Recommendation Report for Planning Permission for Works or Extension to a Dwelling

REF NO: AL/131/25/HH

LOCATION: Tara
Norton Lane
Norton
PO20 3NH

PROPOSAL: Proposed cladding and rendering and alterations to fenestration.

PL02 - Existing Elevations

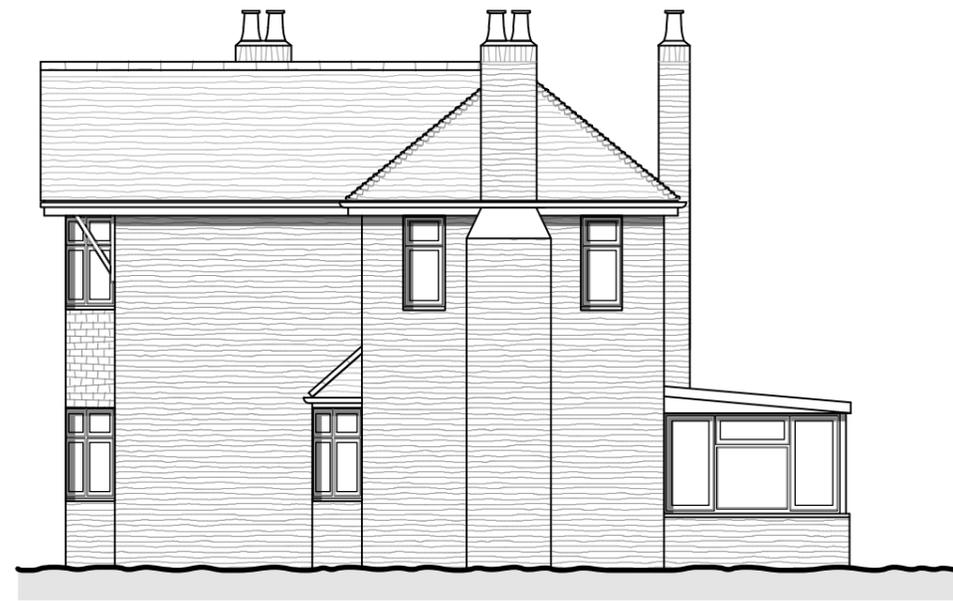
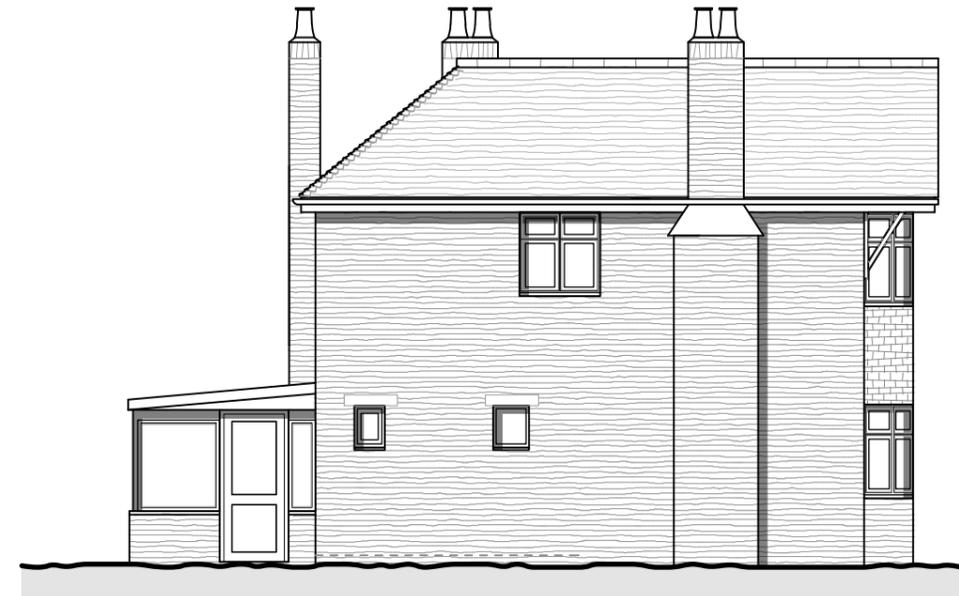
It is proposed that the three existing bay windows to the front elevation would be replaced with square bays and the existing front door would be relocated in place of one of these bay windows. The door would remain within the principle elevation and would not disrupt the existing layout. The proposed alterations to fenestration would be acceptable, given the minor nature of the proposed changes and the existing variation within the street scene.

PL04 - Proposed Elevations

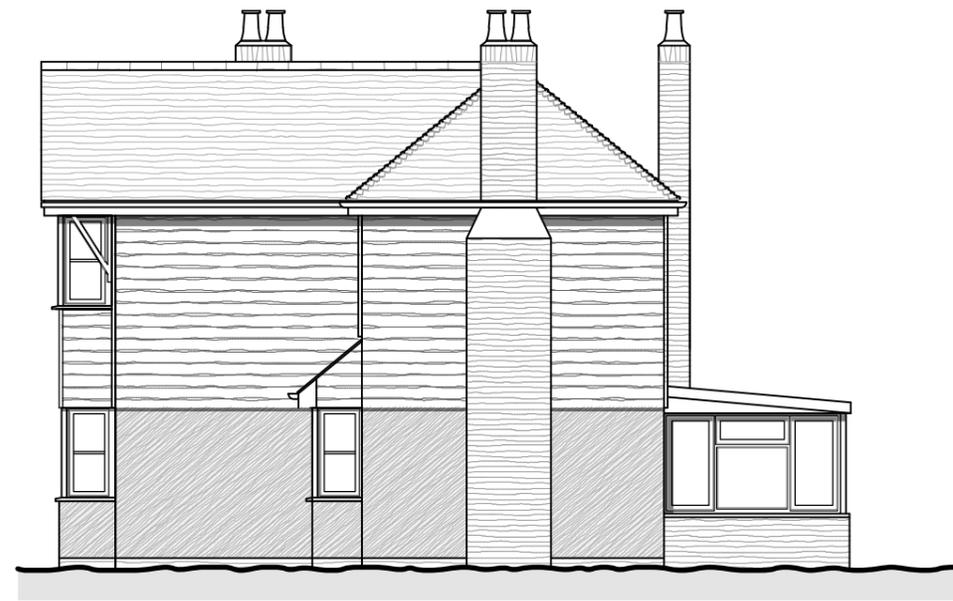
The site is a detached two storey dwelling along Norton Lane, which is generally characterised by large, detached dwellings of varied design with generous front and rear amenity areas. This application seeks planning permission for the cladding and rendering of the dwelling, as well as alterations to fenestration. To the first floor, fibre-cement weatherboard cladding in Cobblestone is proposed and to the ground floor, smooth render in off white. The external finishes would replace facing brickwork.

Lane features a variety of finishes and lacks a single dominant characteristic within the street scene. The proposed cladding has a comparable appearance to tile hanging, which is already present on the existing dwelling. While cladding does not appear in the immediate vicinity of the site, its introduction would not be harmful given the varied character of the area. Additionally, smooth white cladding is present on the neighbouring property to the south. Therefore, the proposed materials are acceptable in terms of design and visual amenity.
